**From:** Contact Centre (CRM) <contact@ribblevalley.gov.uk>  
**Sent:** 12 April 2023 08:58  
**To:** Planning  
**Subject:** Planning Application Comments - 3/2022/0948 FS-Case-506977707

**Planning Application Reference No.:** 3/2022/0948

**Address of Development:** The Manor House Bridge Road Chatburn Clitheroe BB7 4AW

Proposed gable elevation to the roof top dormer 1:100 @ A1

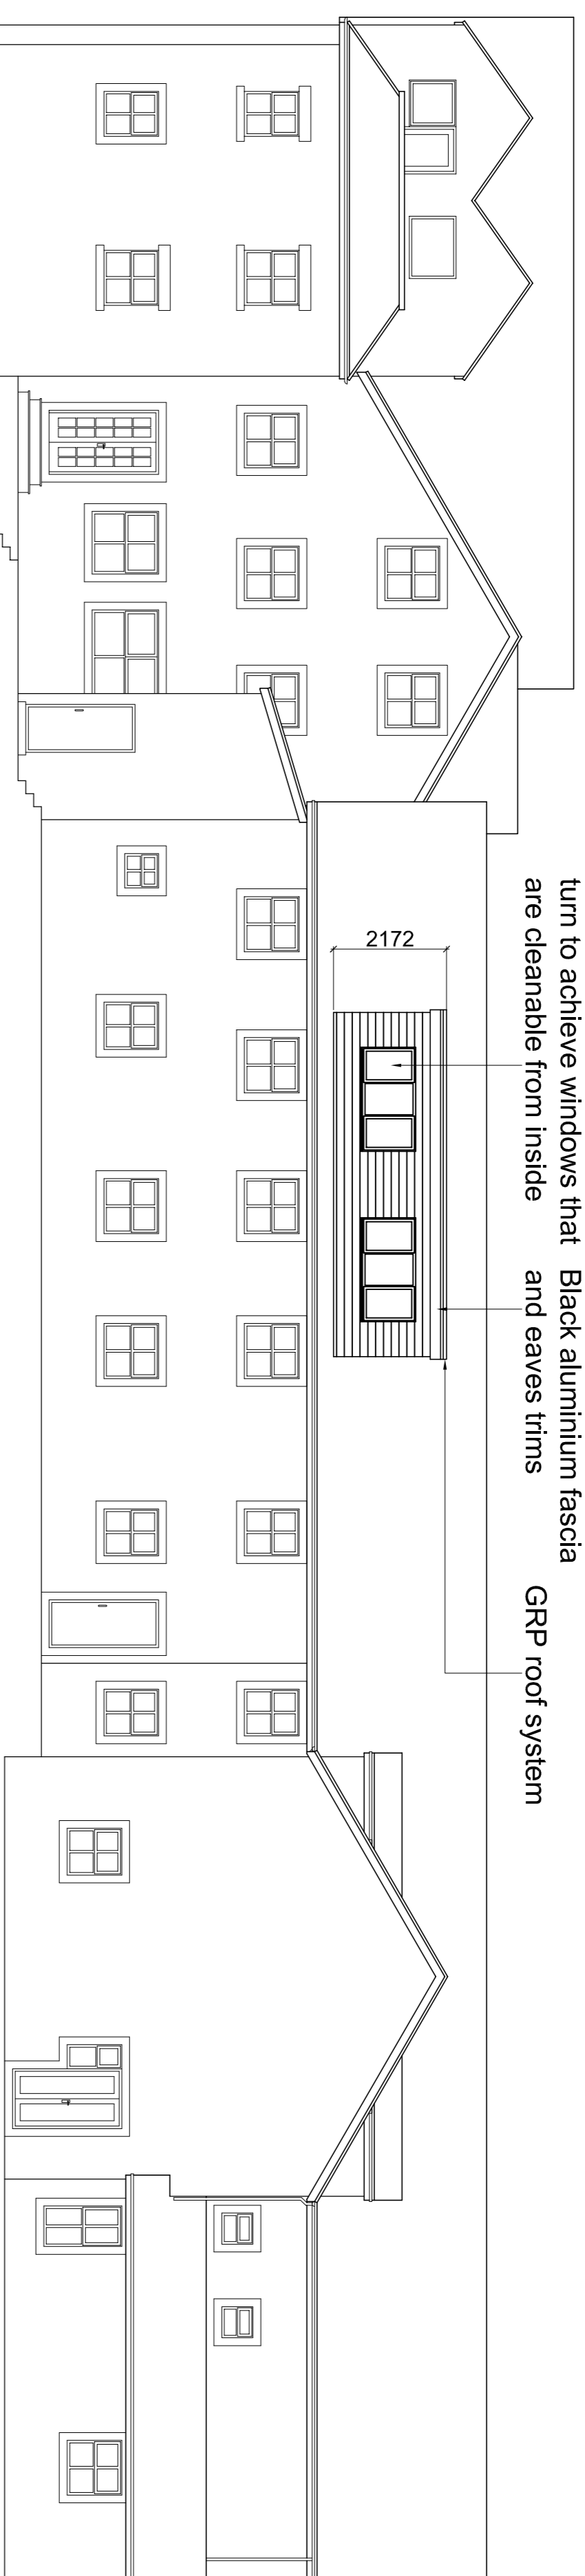
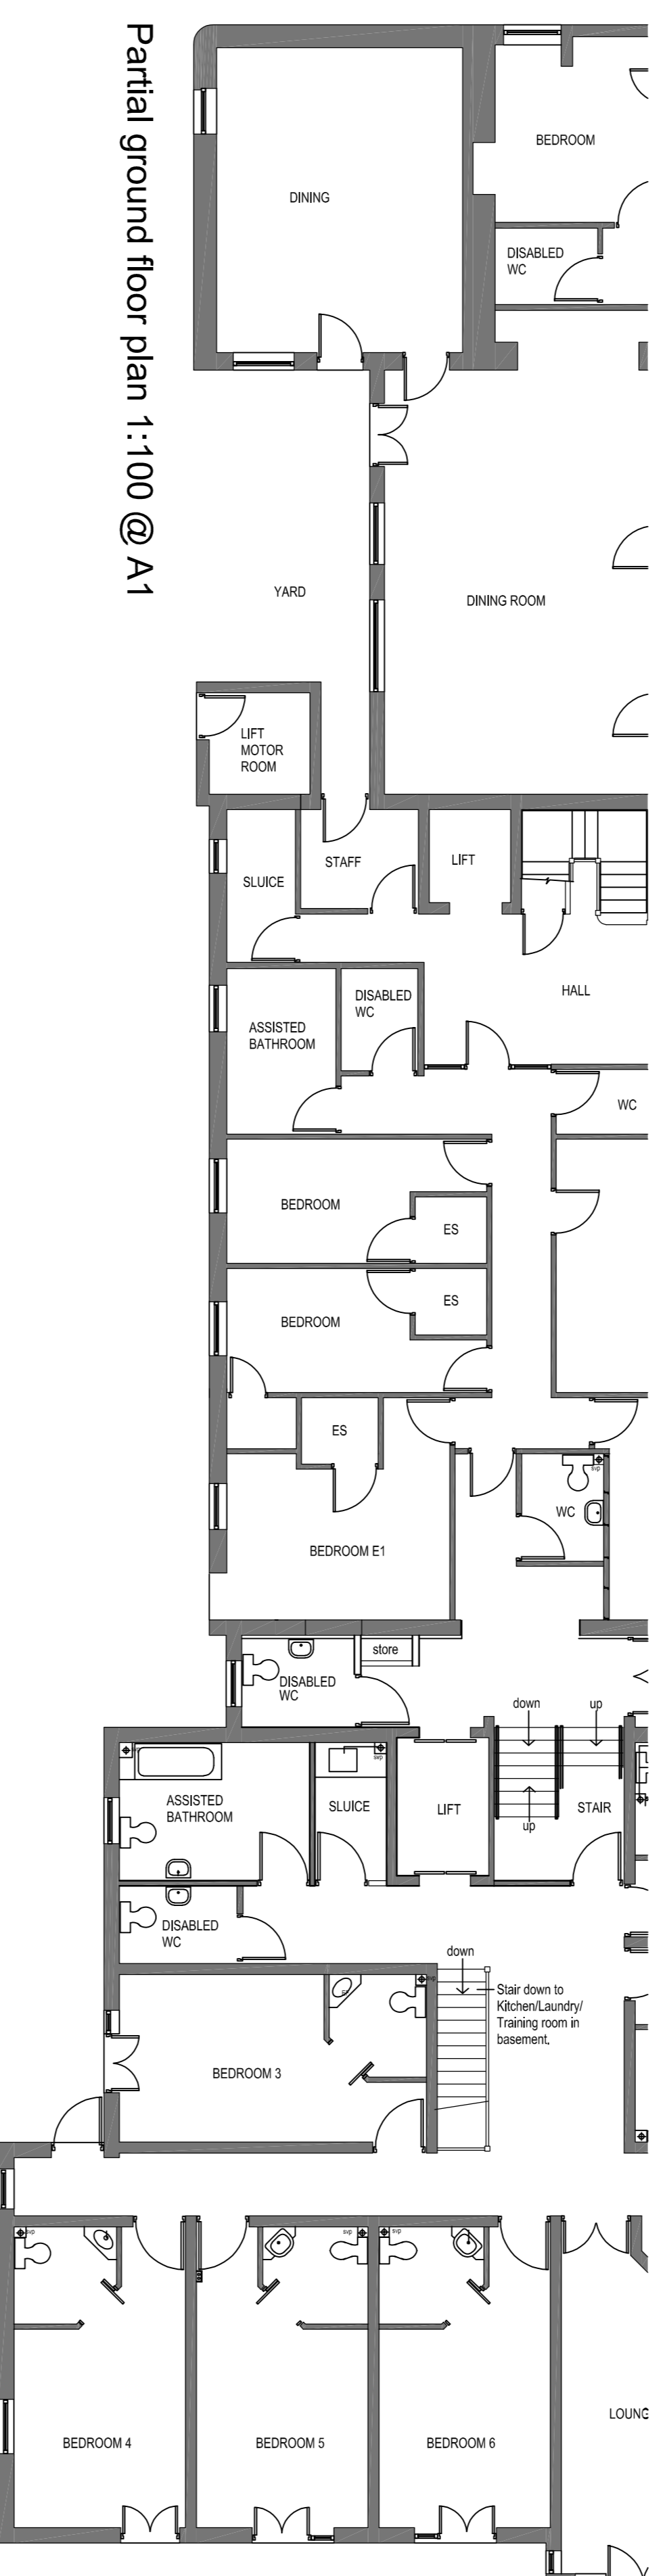
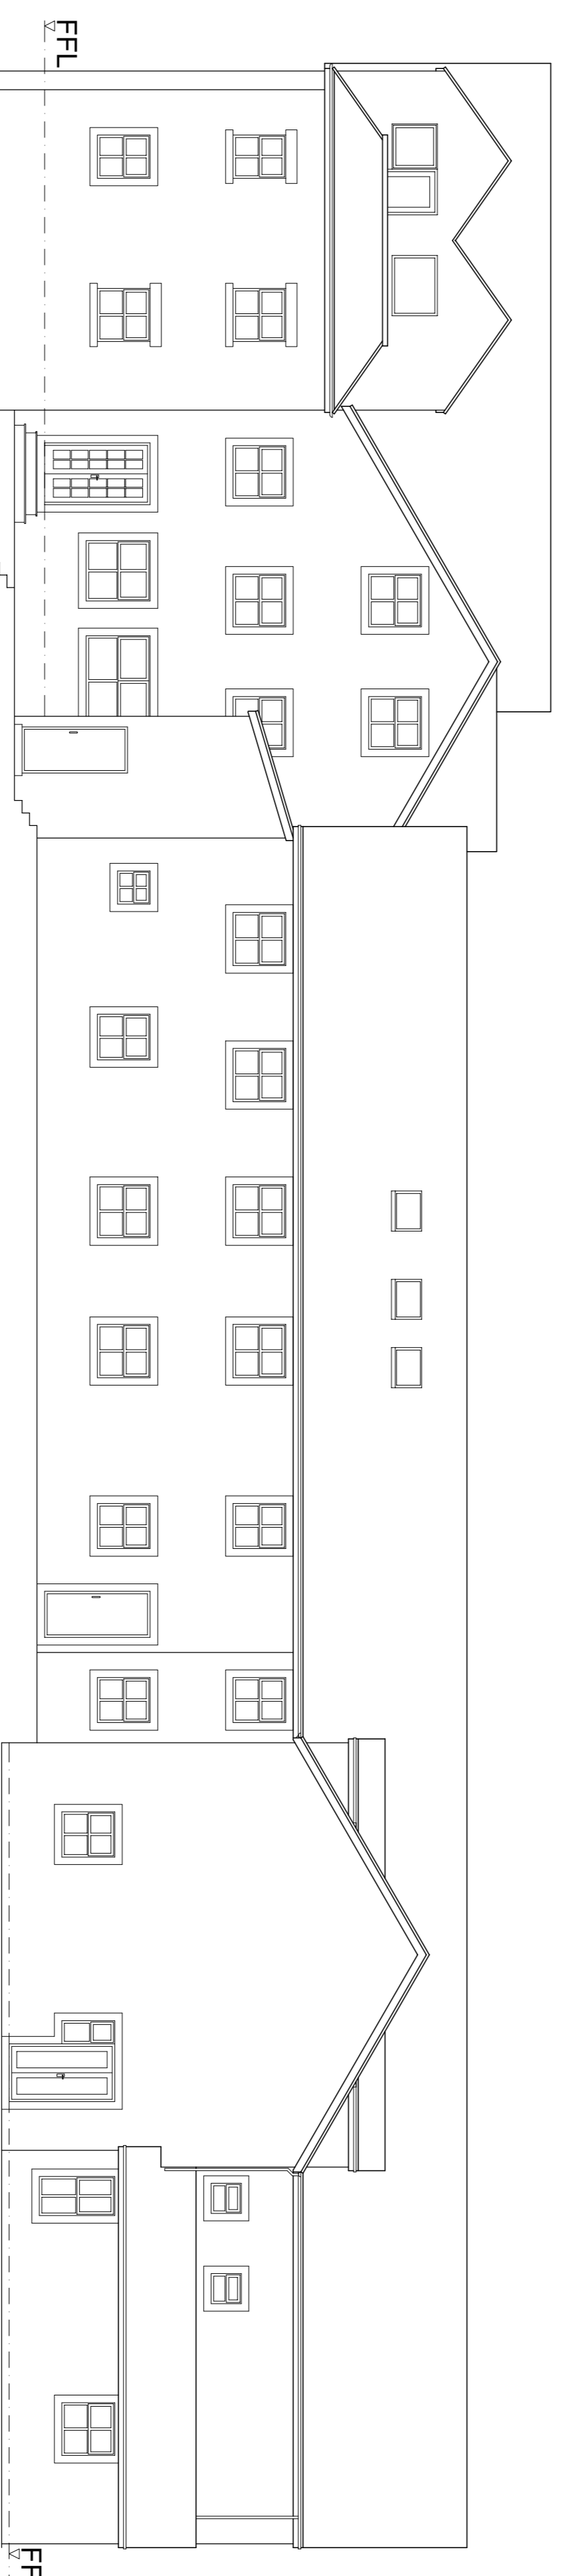
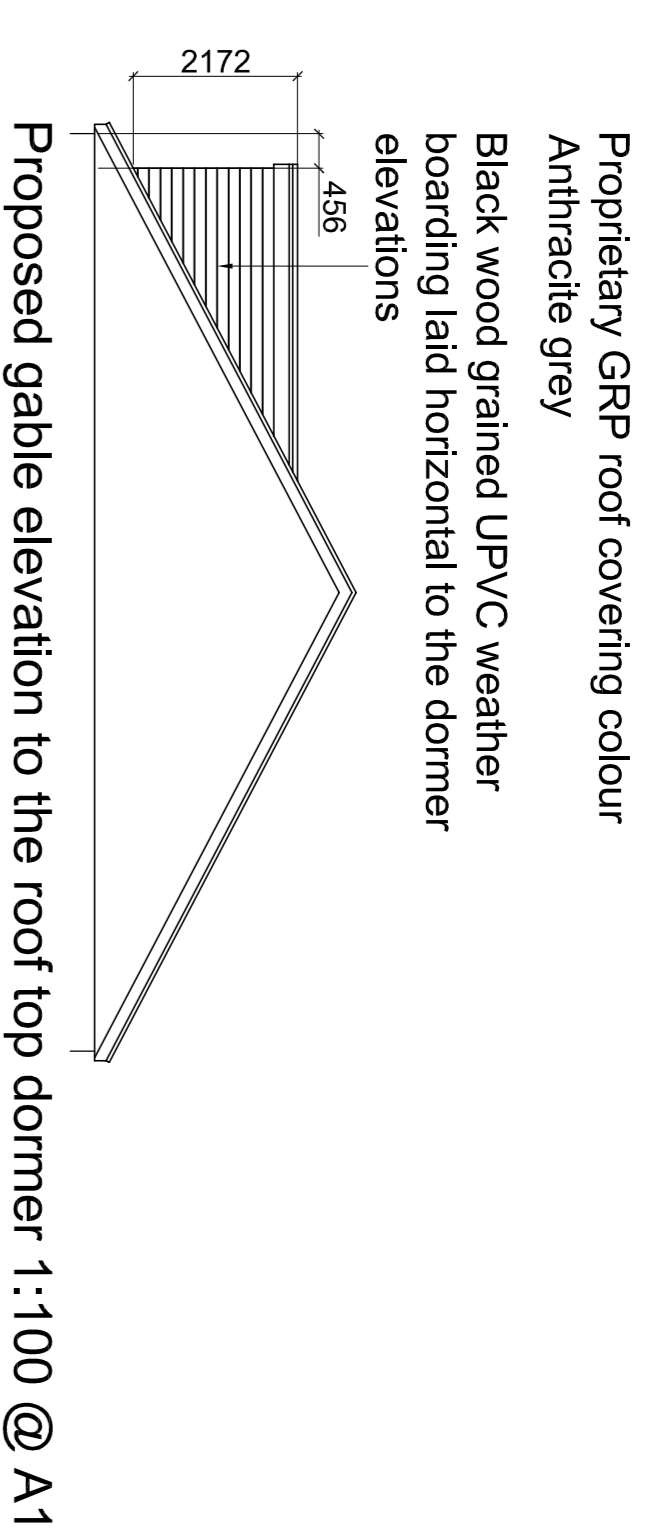
**Comments:** I wish to oppose the extension of the roof top dormer at the back of the Manor House building. [REDACTED]  
[REDACTED] the extension would overlook [REDACTED]  
[REDACTED] It would also cover some of the sky therefore restricting the daylight [REDACTED]  
[REDACTED] [REDACTED] is already overlooked and quite dark with the Manor House being so tall  
therefore this would only exacerbate the issue.
